***RE: WALGREEN'S, WYOMING & MONTGOMERY (G20-D23A). ENGINEER'S
CERTIFICATION FOR CERTIFICATE OF OCCUPANCY APPROVAL.
ENGINEER'S STAMP DATED DECEMBER 5, 2000.***

**RE: WALGREENS - MONTGOMERY AND WYOMING (G20-D23A) GRADING PLAN
FOR BUILDING PERMIT APPROVAL. ENGINEER'S STAMP DATED
FEBRUARY 9, 1996.**

WALGREENS - MONTGOMERY & WYOMING
GRADING & DRAINAGE PLAN

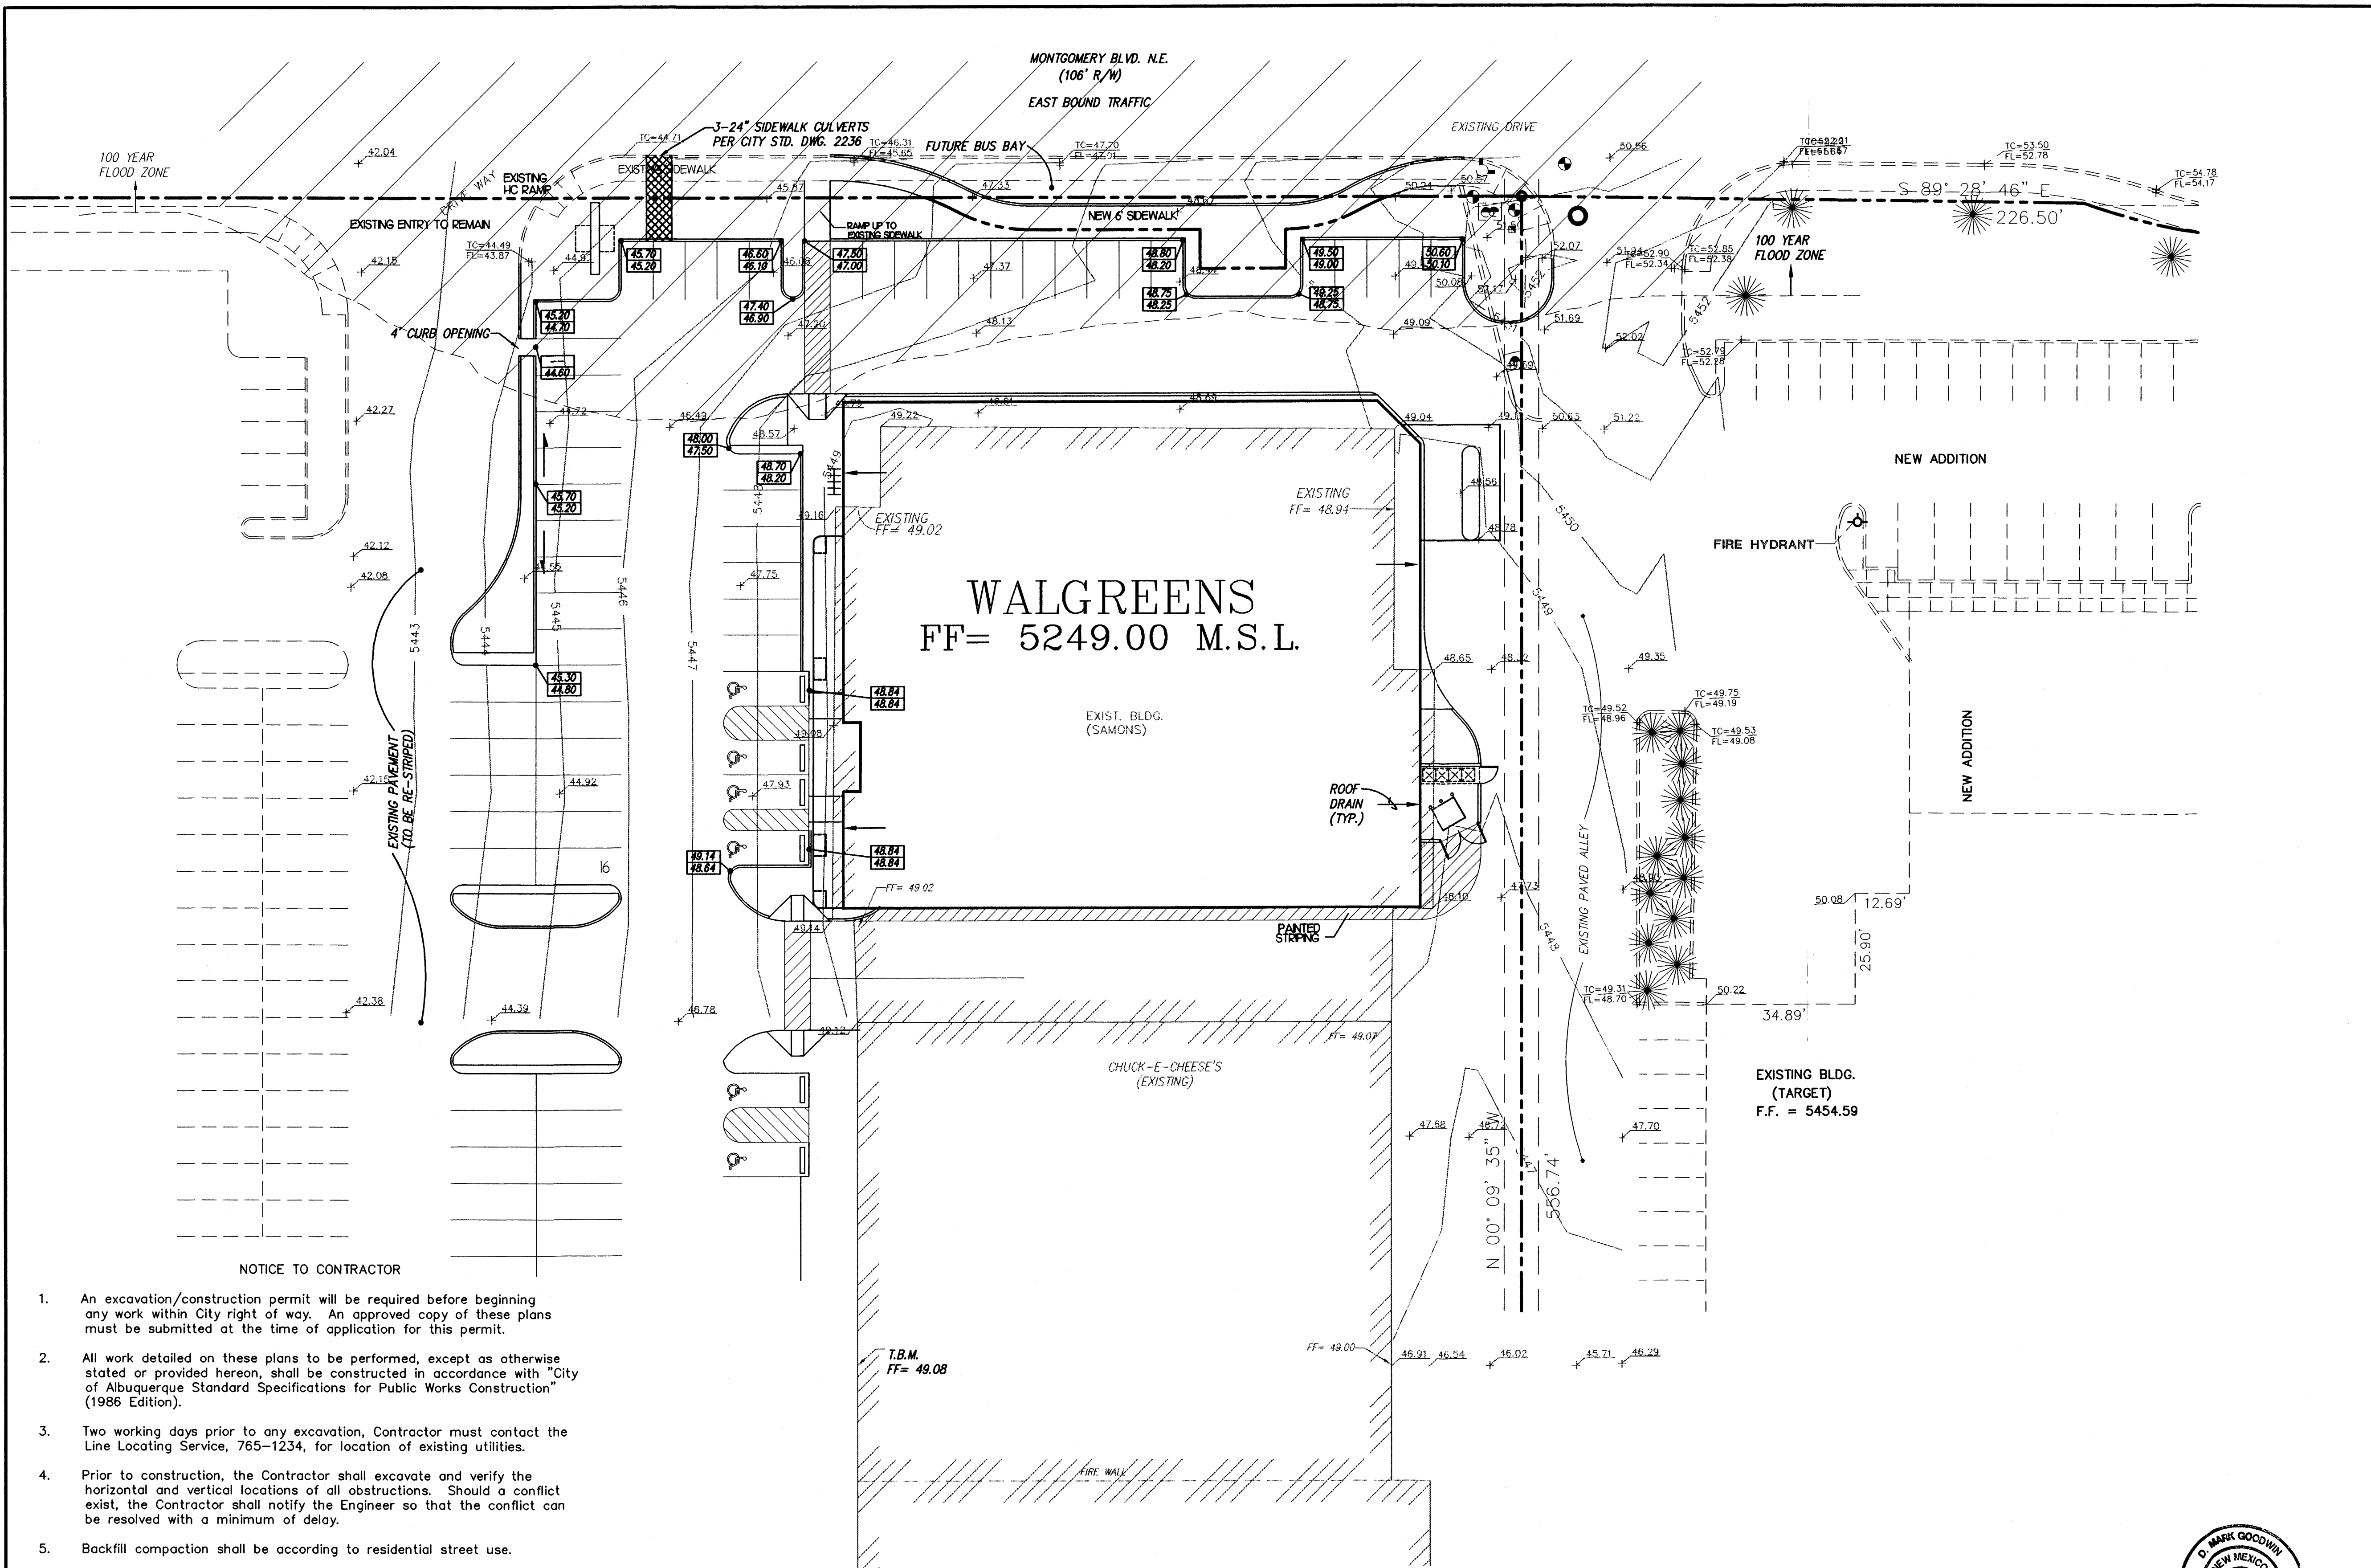
1. Please provide the existing topography for this site.
2. Does any portion of this site lie within a floodplain?
